**State Significant Development Application for WSU Indigenous Centre of Excellence**

Thank you for the opportunity to provide comment on the State Significant Development Application for WSU Indigenous Centre of Excellence at Western Sydney University, 171 Victoria Road, Parramatta. It is understood that the proposed development seeks approval for:

Peter Cinque  
Manager Emergency Risk Assessment  
**NSW State Emergency Service**

DRAWING TITLE
PROPOSED FLOOR PLAN_LEVEL G

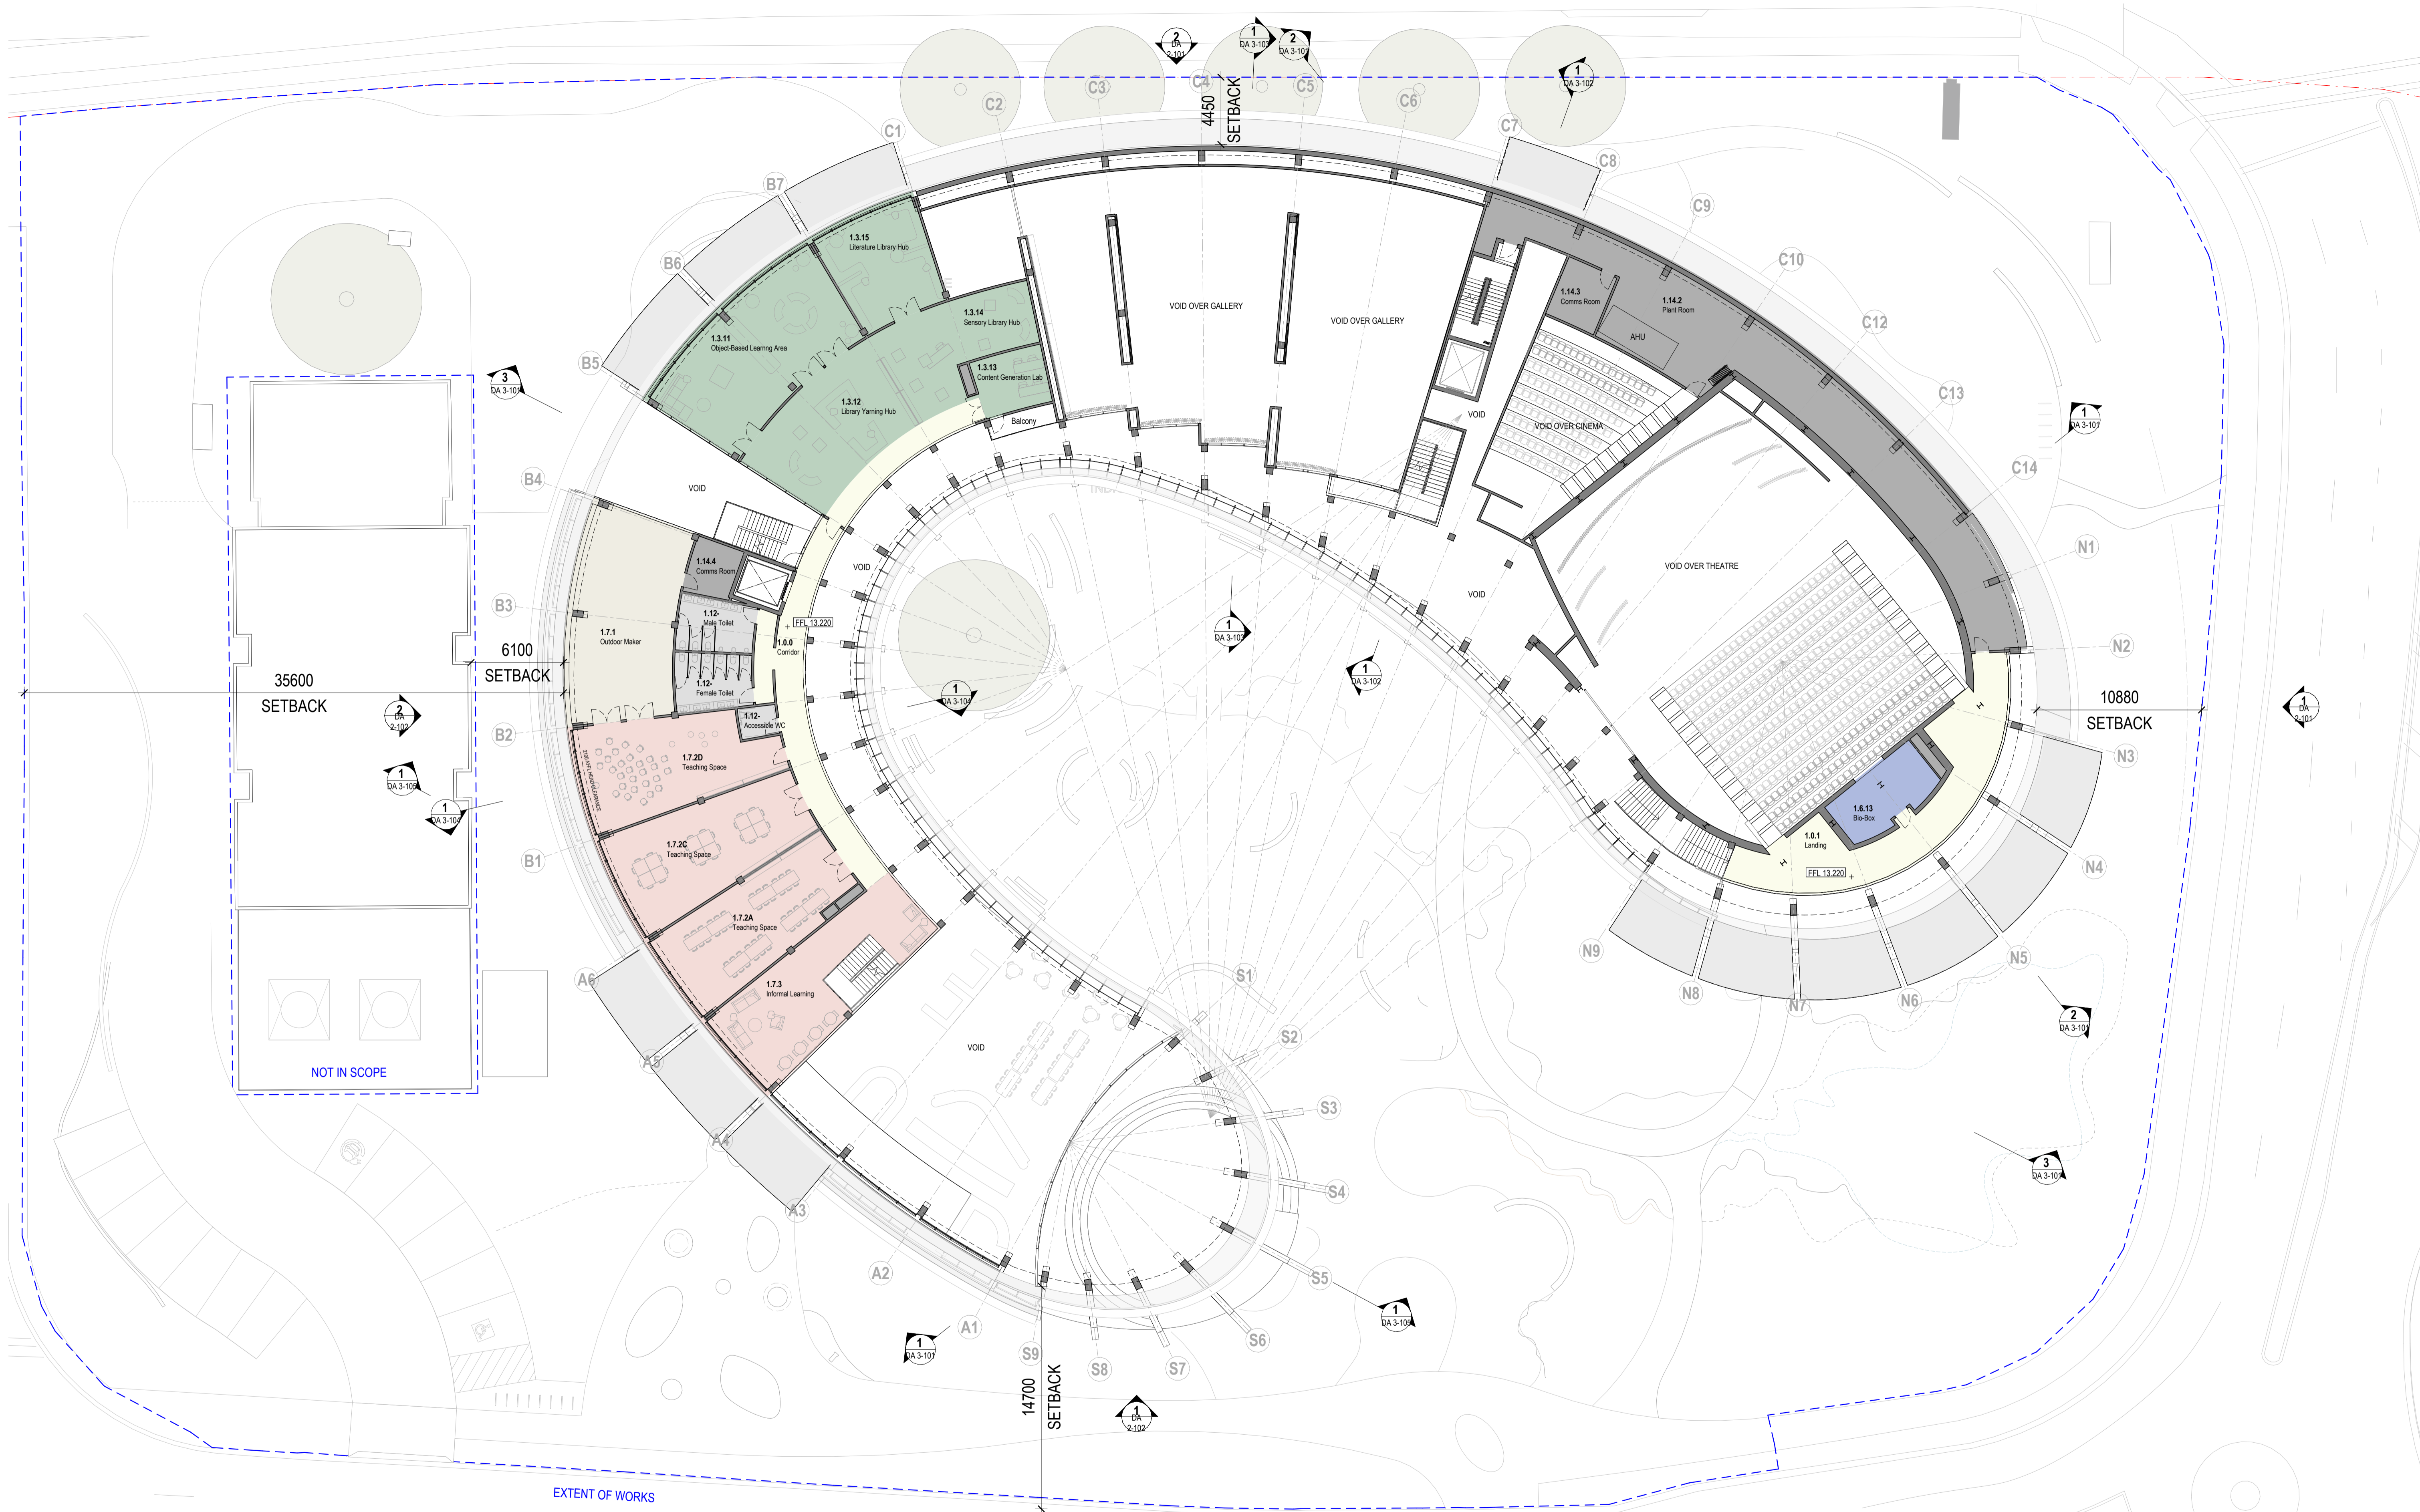
- **Recommend** consideration of safety features for proposed lifts, to ensure that floodwater does not enter the lift, and ensure people do not exit into flooded areas.

- **Recommend** careful consideration to the use of lifts in any vertical evacuation strategy. While the FERP states “*Whilst stairways are the encouraged vertical*

*evacuation route, elevators can continue to be used to vertically evacuate persons requiring assistance to the first level<sup>9</sup>, during a PMF event flood water is modelled to reach 1.4 metres above floor level<sup>10</sup>.*
